From: [Pat Nicholson](#)
To: [Rachael Stevie \(CD\)](#)
Subject: RE: BL-20-00007 McKenna - Notice of Application
Date: Tuesday, March 10, 2020 2:31:16 PM
Attachments: [image001.png](#)

From: Rachael Stevie (CD) <rachael.stevie.cd@co.kittitas.wa.us>
Sent: Monday, March 9, 2020 4:19 PM
To: Pat Nicholson <pat.nicholson@co.kittitas.wa.us>; Candie Leader <candie.leader@co.kittitas.wa.us>; Holly Erdman <Holly.erdman@co.kittitas.wa.us>; Jesse Cox <jesse.cox@co.kittitas.wa.us>
Cc: Lindsey Ozbolt <lindsey.ozbolt@co.kittitas.wa.us>
Subject: BL-20-00007 McKenna - Notice of Application

Please review the following Boundary Line Adjustment application submitted by Lon Paul & Michelle Gienger and John & Patricia McKenna (BL-20-00007). Any comments need to be submitted by 5pm on March 24, 2020. Please let me know if there are any questions.

JOHN McKENNA
BOUNDARY LINE ADJUSTMENT
SITE PLAN

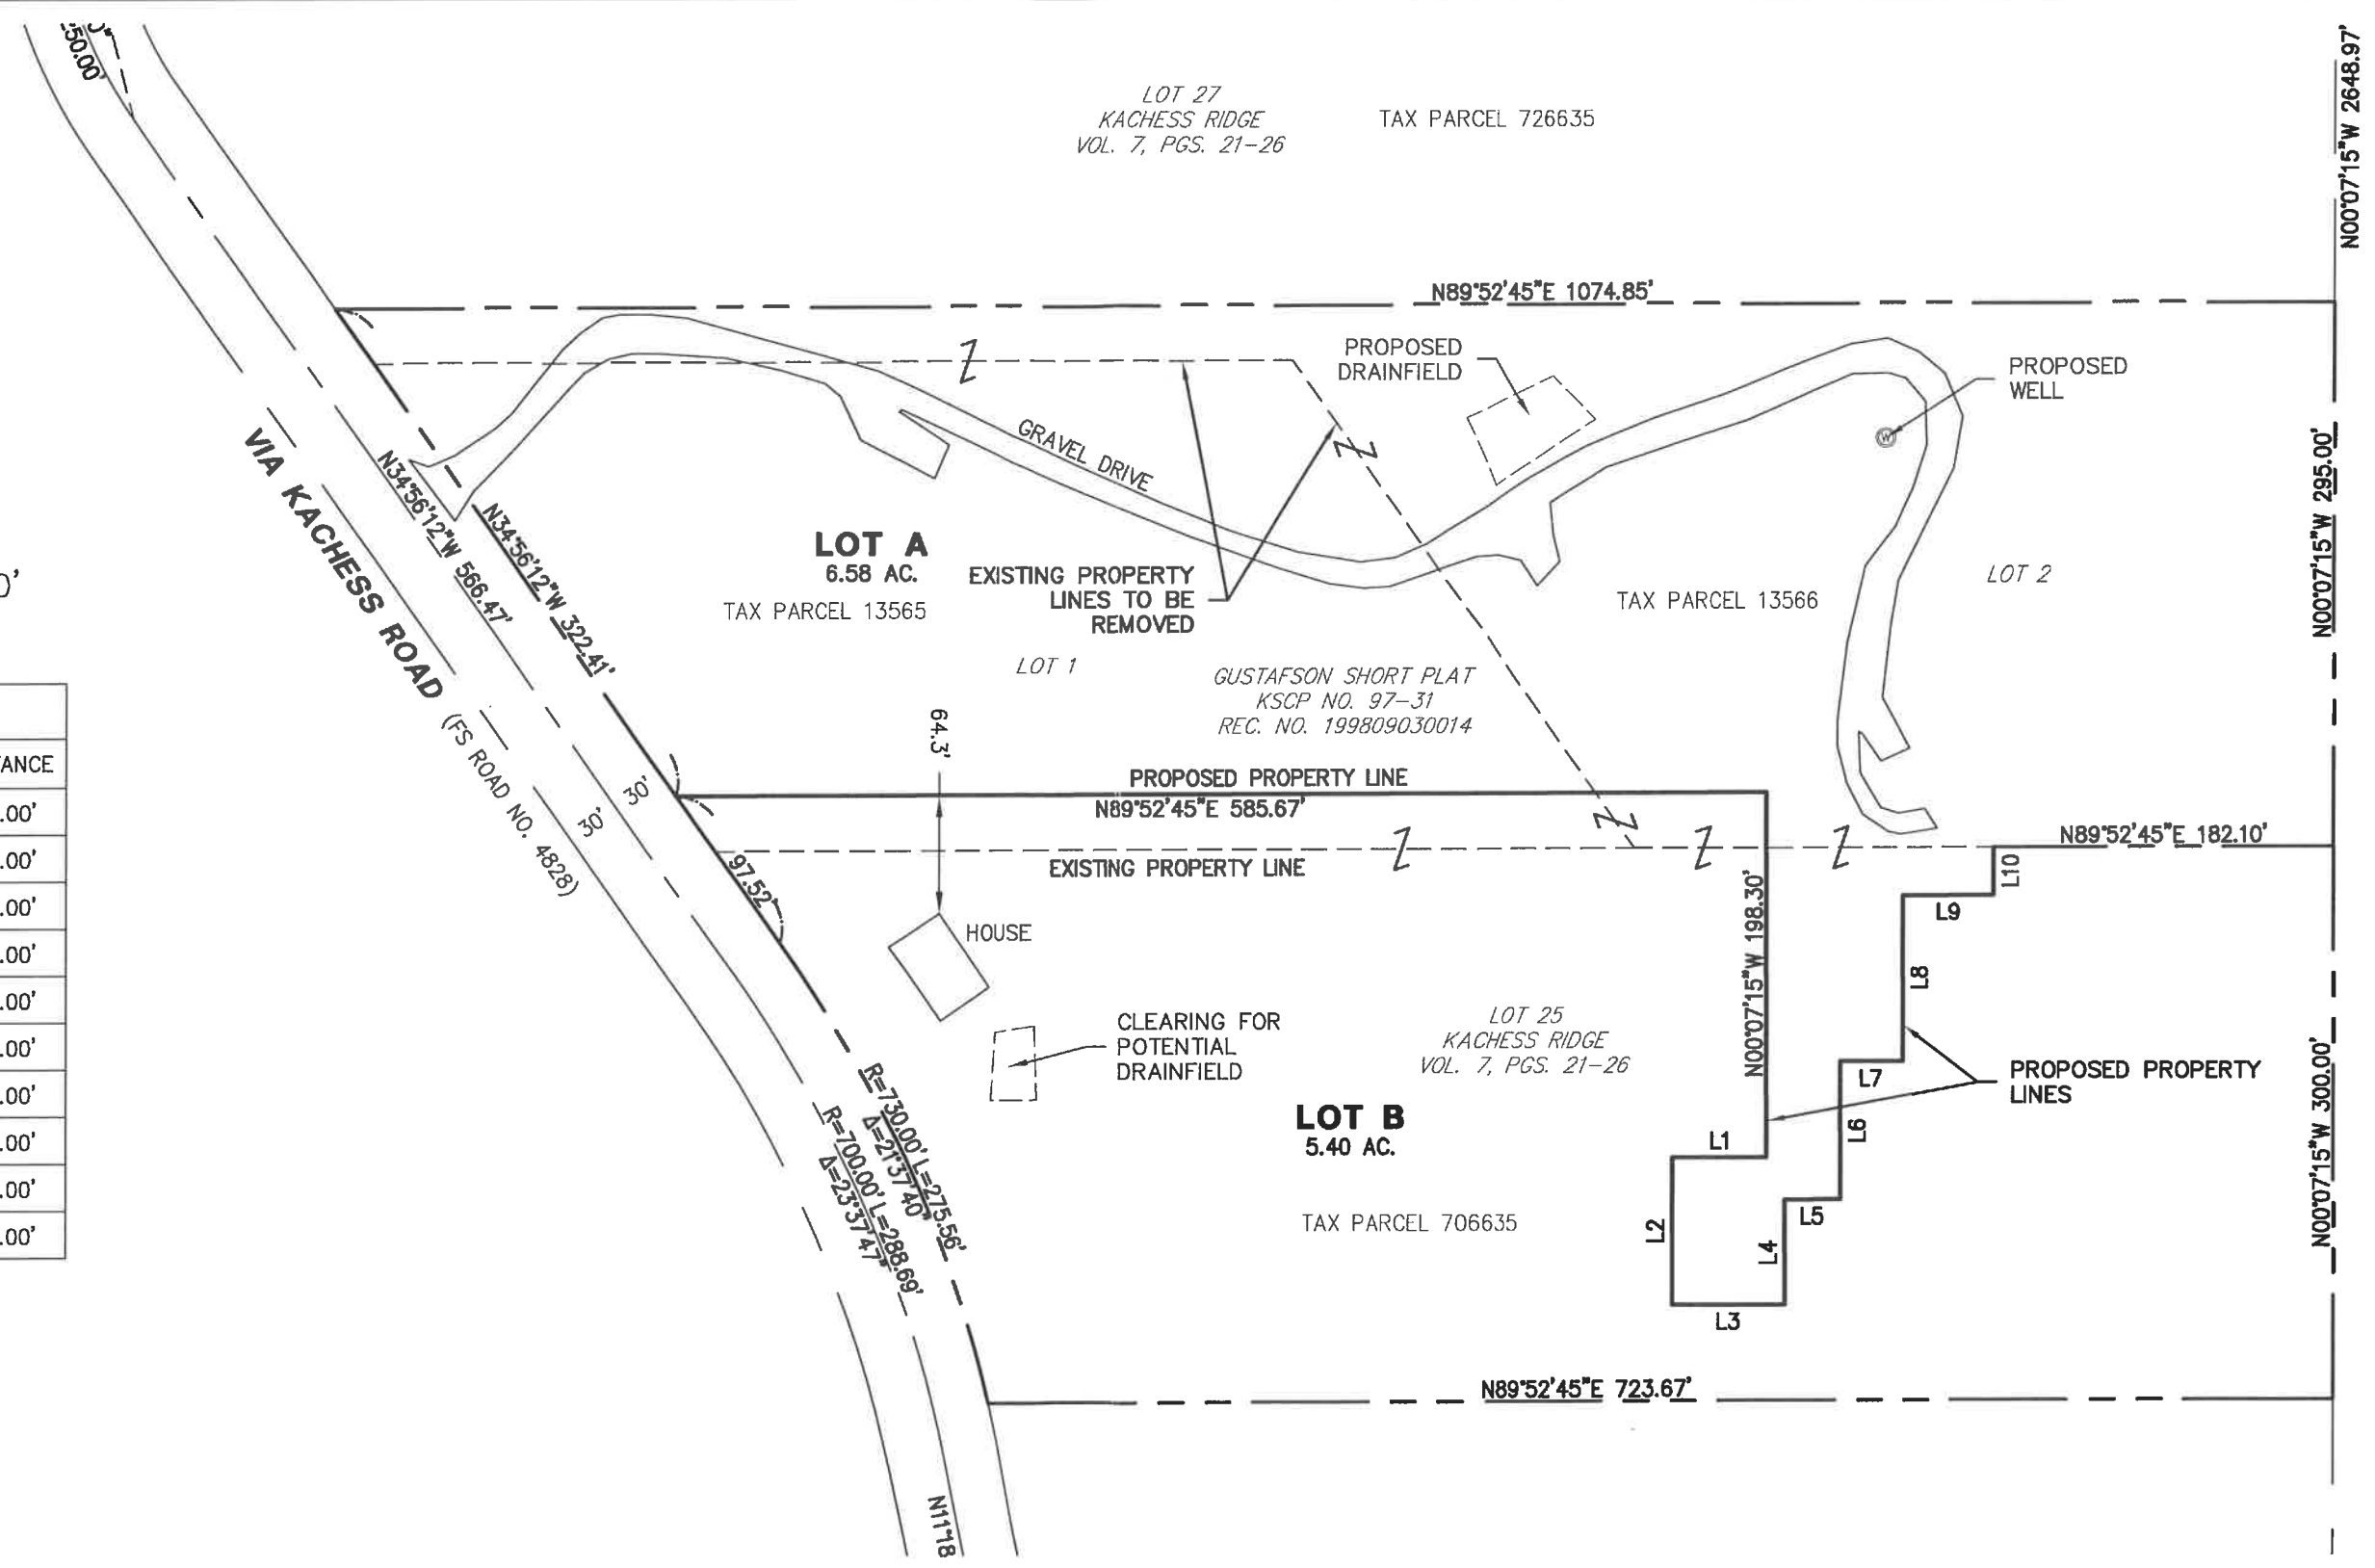
Gravel drive to be IFC and PW compliant for width, grade, and capacity.
